Ann Machado - RE: 68 Commercial Street - Building A (aka #1) - Permit #2014-01013

From: Susan Geffers <sue@archetypepa.com>
To: Ann Machado <AMACHADO@portlandmaine.gov>
Date: 6/25/2014 1:52 PM
Subject: RE: 68 Commercial Street - Building A (aka #1) - Permit #2014-01013

I have finished my initial zoning review. I need some more information before I can sign off on the permit and move it forward in the review process.

SHEET NO.
 9

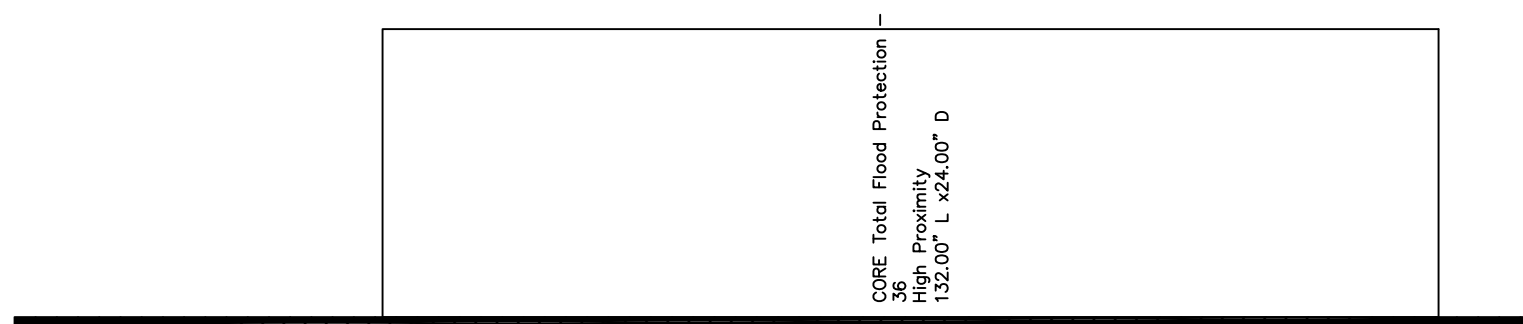
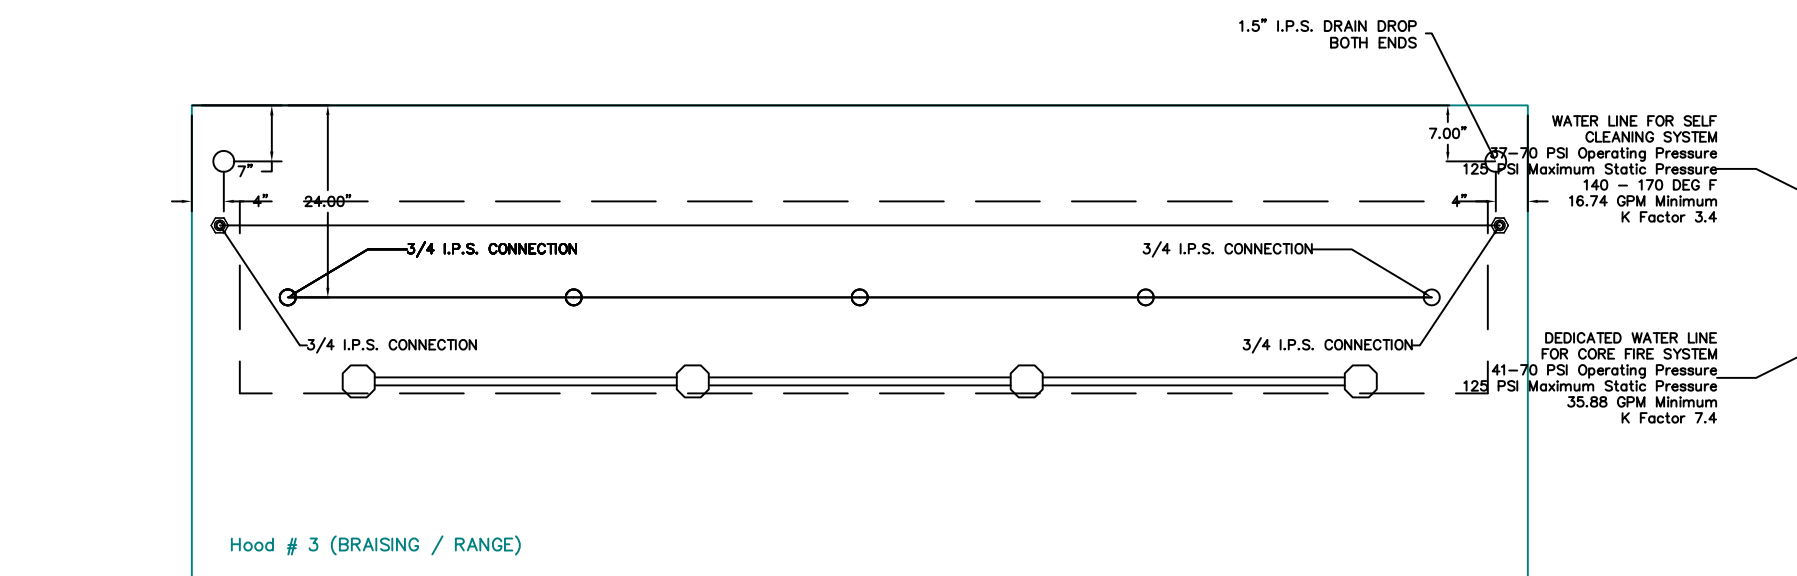
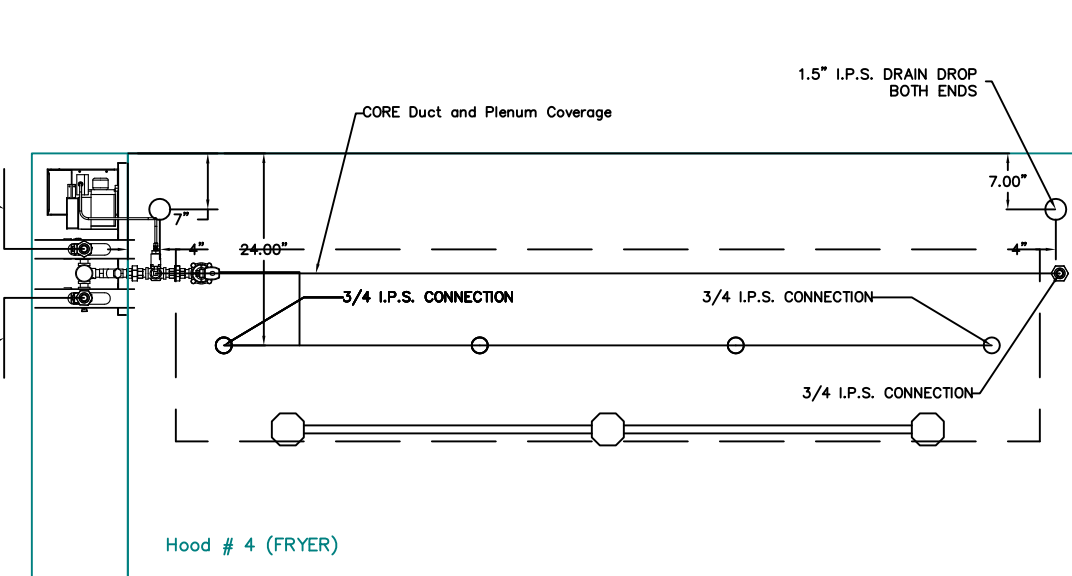
2. You included plans for the hood (HD-1 thru HD-9). A separate hood permit will still have to be applied for.
3. The property and Building A in particular is located in the WCZ zone outside of the Non-Marine Use Overlay Zone. Section 14-311(a)(1) requires that 55% of the ground floor must be marine use. You need to show that the restaurant and retail space do not occupy more than 45% of the total ground floor area of all buildings on the lot.

2. You included plans for the hood (HD-1 thru HD-9). A separate hood permit will still have to be applied for.
Understood
